SSD - 9494 – PROPOSED NEW PRIMARY SCHOOL, LOT 1 DP1253855, ESTELLA ROAD, ESTELLA.

I refer to your correspondence regarding the subject Application which was referred to Transport for NSW for assessment and comment.

CAR SPACES:	21
ACCESSIBLE CAR SPACES:	1
BICYCLE:	40
DELIVERY MRV:	1

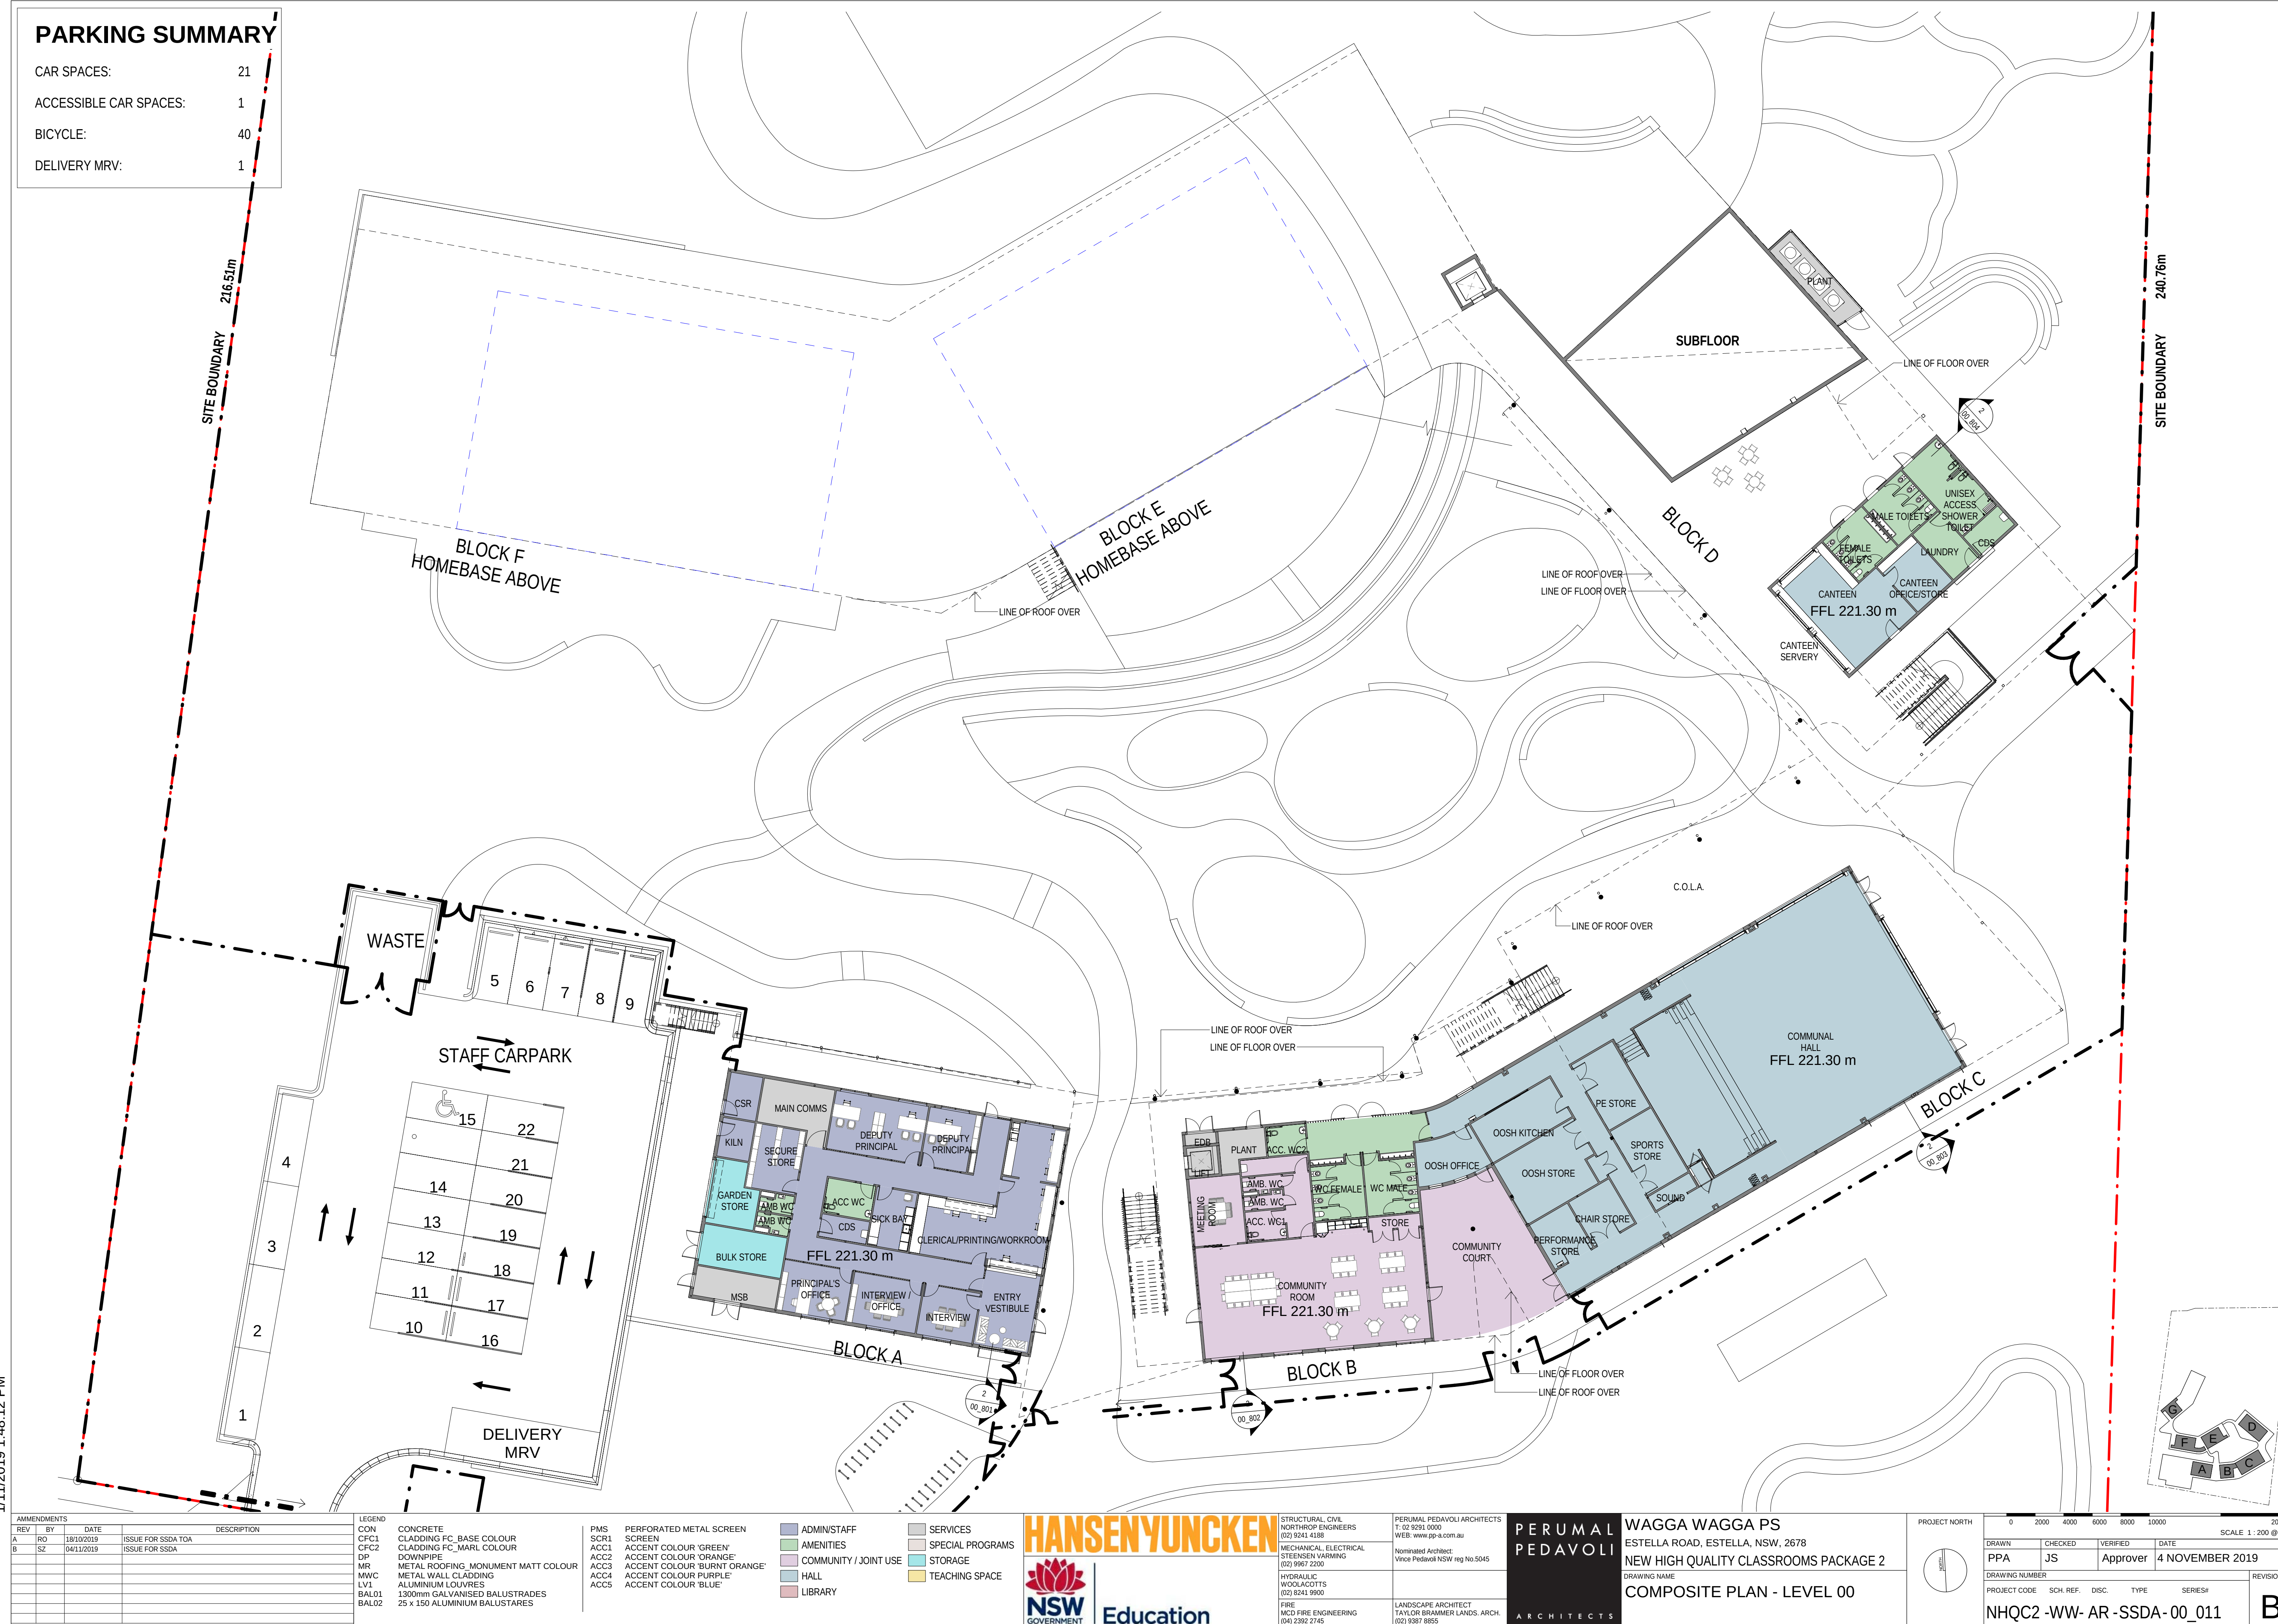
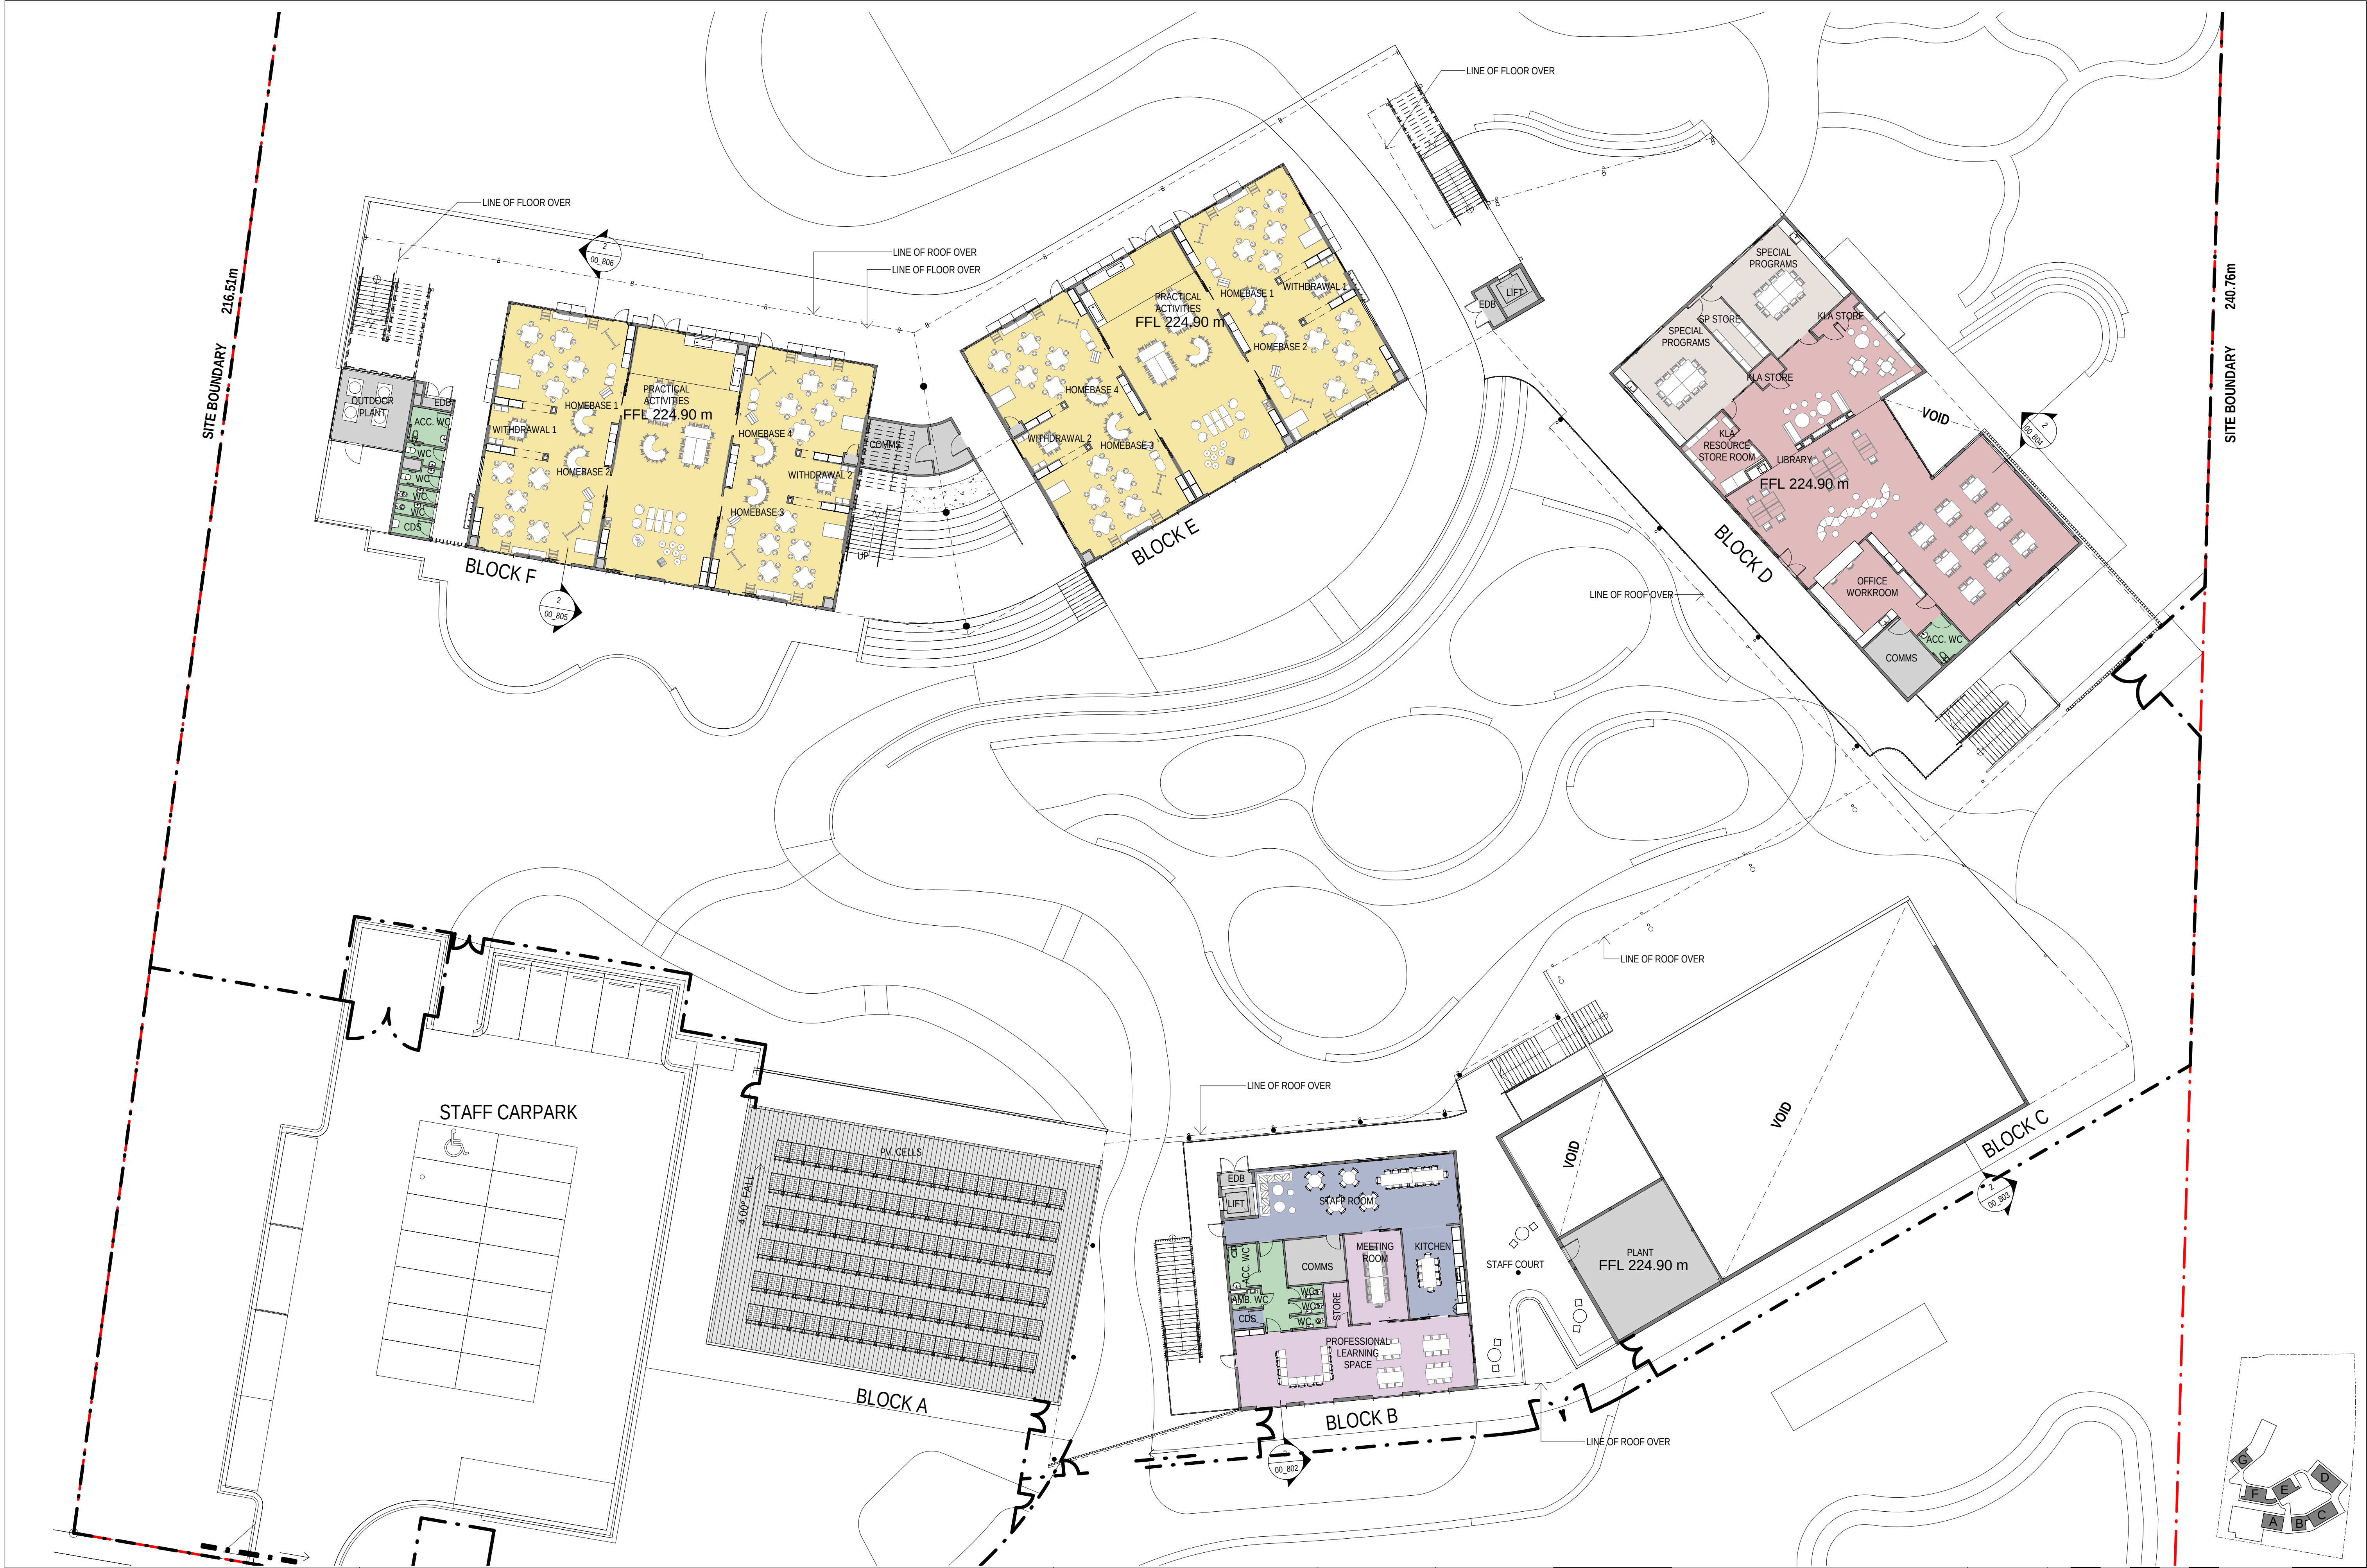
The development provides for an on-site carpark catering for 22 parking spaces for staff and visitors and facilities for bicycle parking within the school grounds. A pick-up/drop-off zone and a bus bay with a capacity for 2 buses is proposed to be located within the road reserve of Estella Road. Estella Road is currently constructed as a rural road formation with a swale drain located along both sides of the road formation. The pick-up/drop-off zone and a bus bay are proposed to be located within the roadside currently occupied by the swale drain and opposite the intersection of Gunn Drive with Estella Road. The location of the bus bays to the east of the proposed school away from the school grounds may need to be further designed and managed to ensure appropriate supervision is available by school staff of children accessing the buses.

The pick-up/drop-off zone is proposed to be one-way east bound with exit from this facility to Estella Road to be located in close proximity to the approach side to the pedestrian crossing facility proposed across Estella Road. The proposed operation of the pick-up/drop-off zone needs to be managed to ensure the theoretical capacity of the facility as posed by the supporting documentation is achieved. The TIA in its assessment of the capacity of the pick-up/drop-off zone doesn't appear to consider the delay to vehicles exiting the facility caused by the use of the crossing facility or vehicles wishing to turn right from the facility or turn across Estella Road to Gunn Drive. It is noted that the TIA recommends that a Traffic and Pedestrian Management Plan (TPMP) be developed by the Department of Education and the School, to be reviewed on an annual basis to establish inefficiencies and areas for improvement, particularly in regard to the operation of the pick-up/drop-off zone. As a minimum the exit driveway from the pick-up/drop-off zone shall be designed to allow for a separate left and right turn lane.

From the submitted plans it appears that the proposed setback for the school is approximately 20 metres from the road reserve of Estella Road and the footprint of the school buildings appear to occupy only the southern part of the site. From the information available it appears that the footprint of the school buildings could be moved northward on the site to increase the setback from Estella Road. The potential for the location of the pick-up/drop-off zone and/or the bus bay within the school grounds and the relocation of the proposed driveways may aid to address a number of the issues outlined above.
